**Alexandria Park
Community School**
7-11 Park Road, Alexandria

**Architectural
and
Urban Design**
Response to Submissions

Prepared for
NSW Department of Education

April 2018 | Issue C

AR.DA. 5001 P1

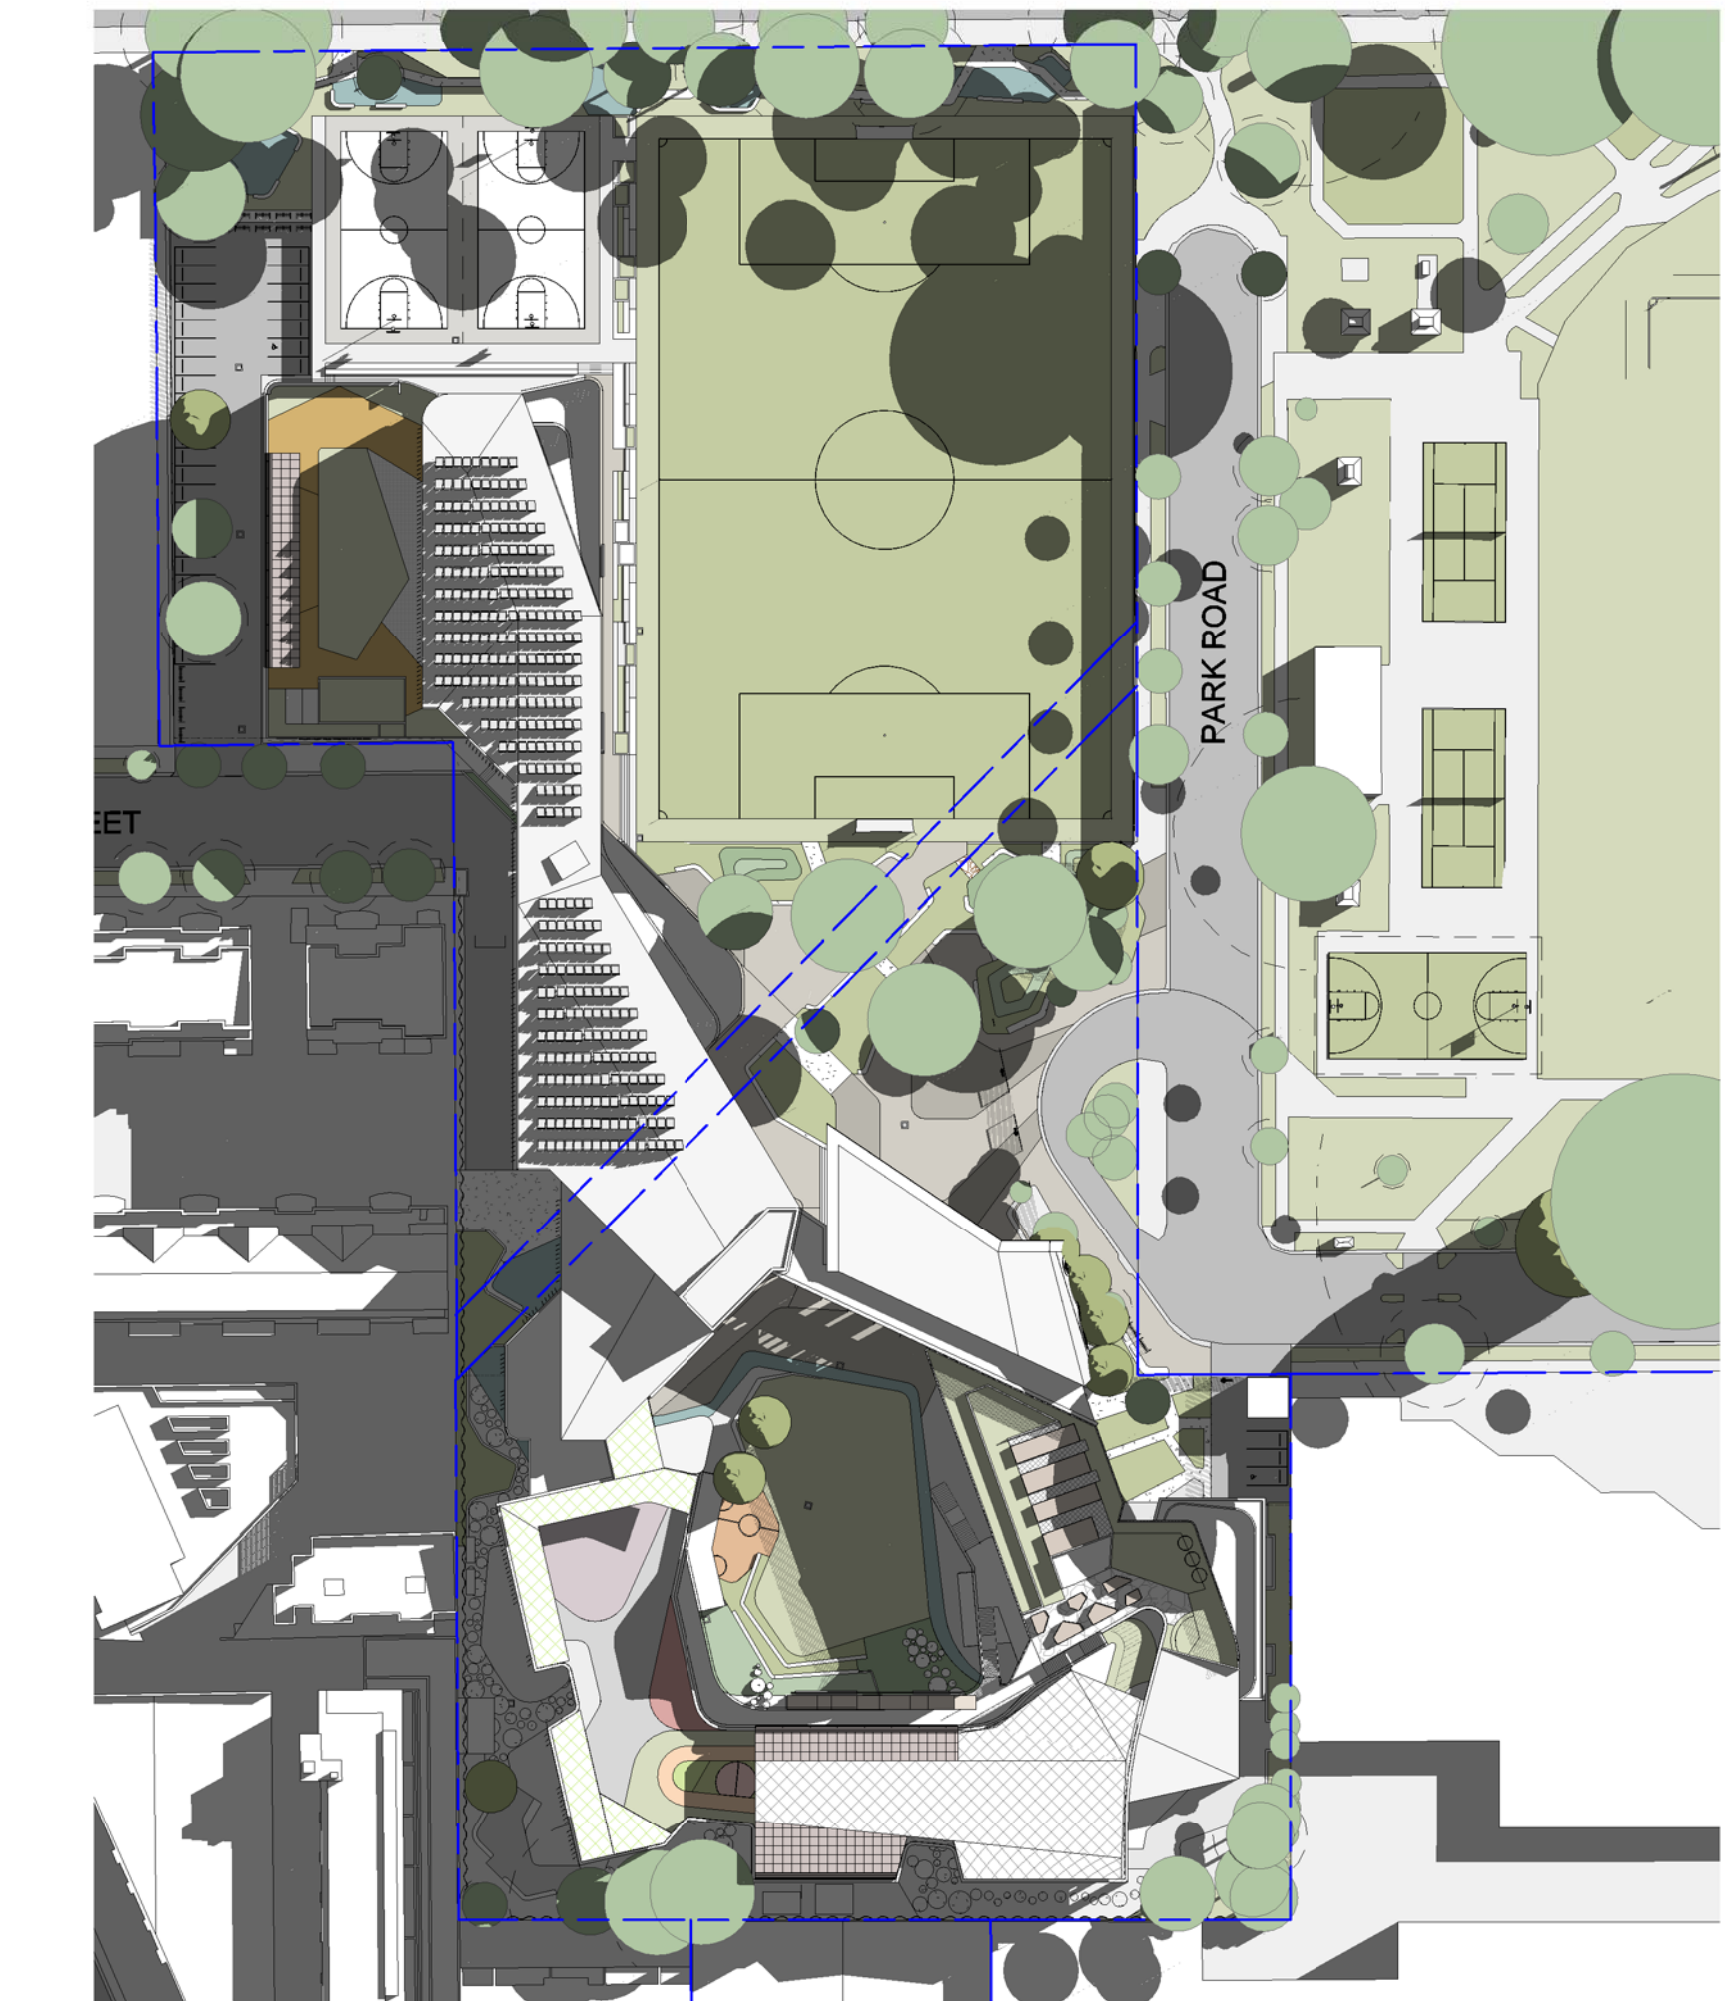
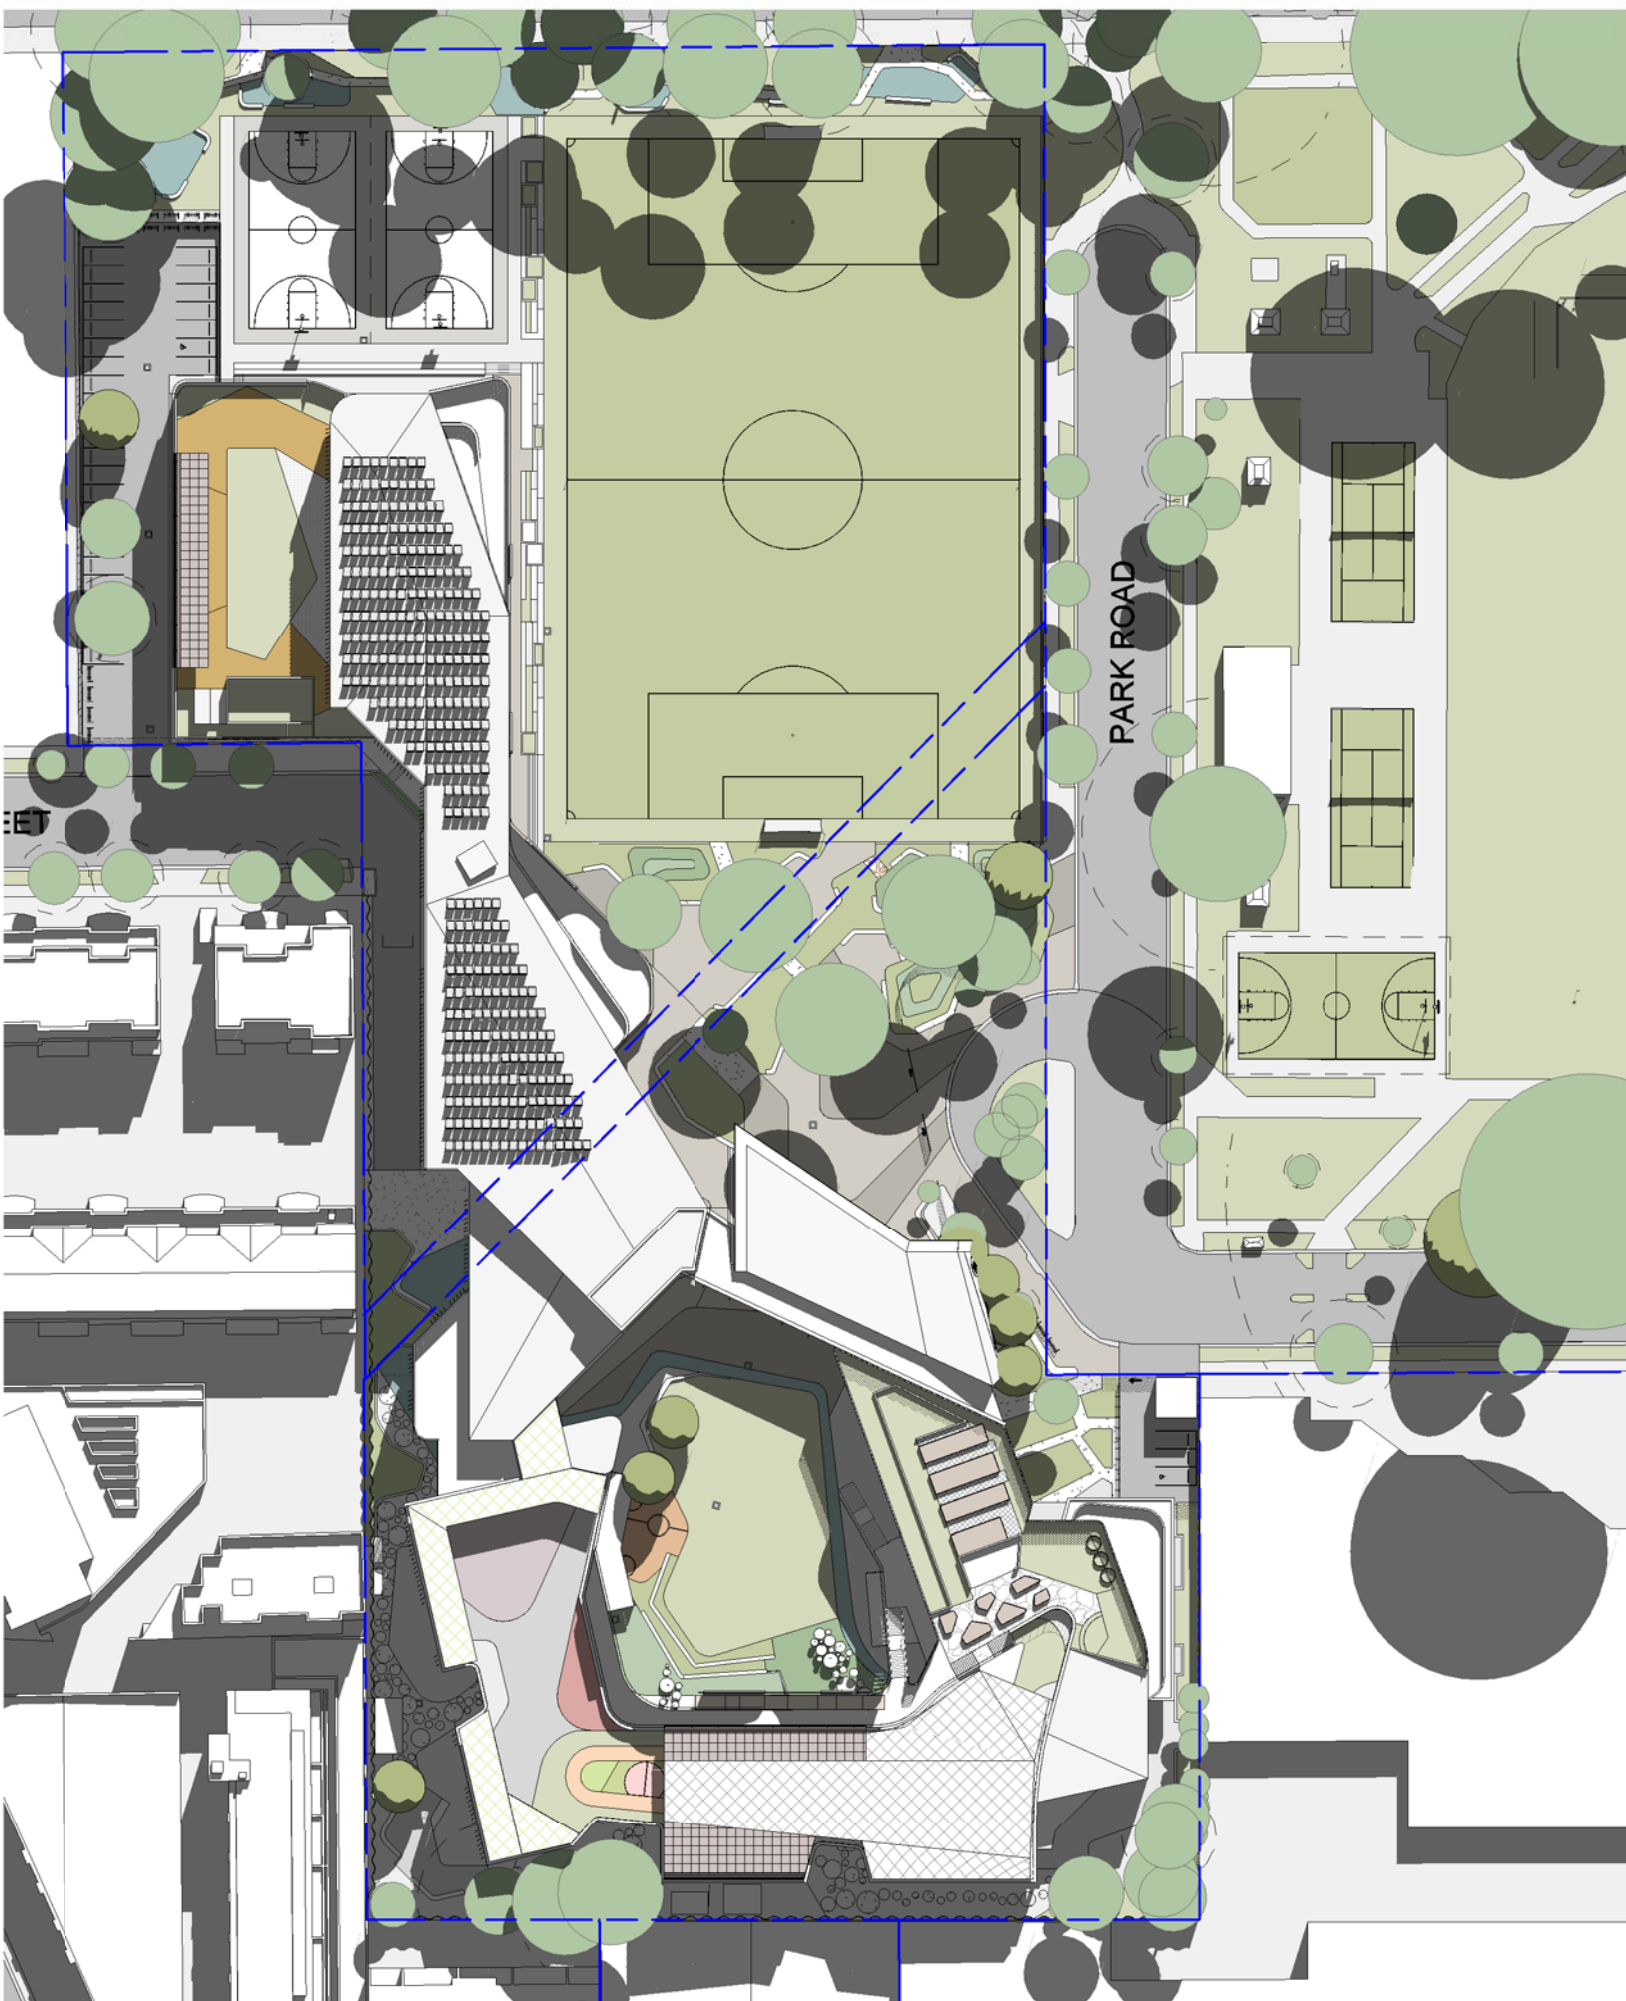
Further analysis of the shadow impact has focused on the residential developments to the west and south of the school. This analysis has reviewed the amount of solar access available to key living spaces of developments during the midwinter solstice and has compared existing (pre-redevelopment), as submitted, a notional 'complying height' development and amended development profiles should this be necessary. The two key residential developments are 58-60 Belmont Street and 141-143 McEvoy Street. The more detailed analysis has shown that these residential developments were affected to such a degree that the submitted design required modification to ensure that adequate solar access would continue to be provided each development. Other developments were not affected.

The proposed amendments involves shifting the gymnasium block and associated learning spaces 3m to the north and reducing the height of the gymnasium block along the edge facing Belmont Street. These two changes have greatly improved the solar access to apartments in this development as shown in the diagrams and views in the report.
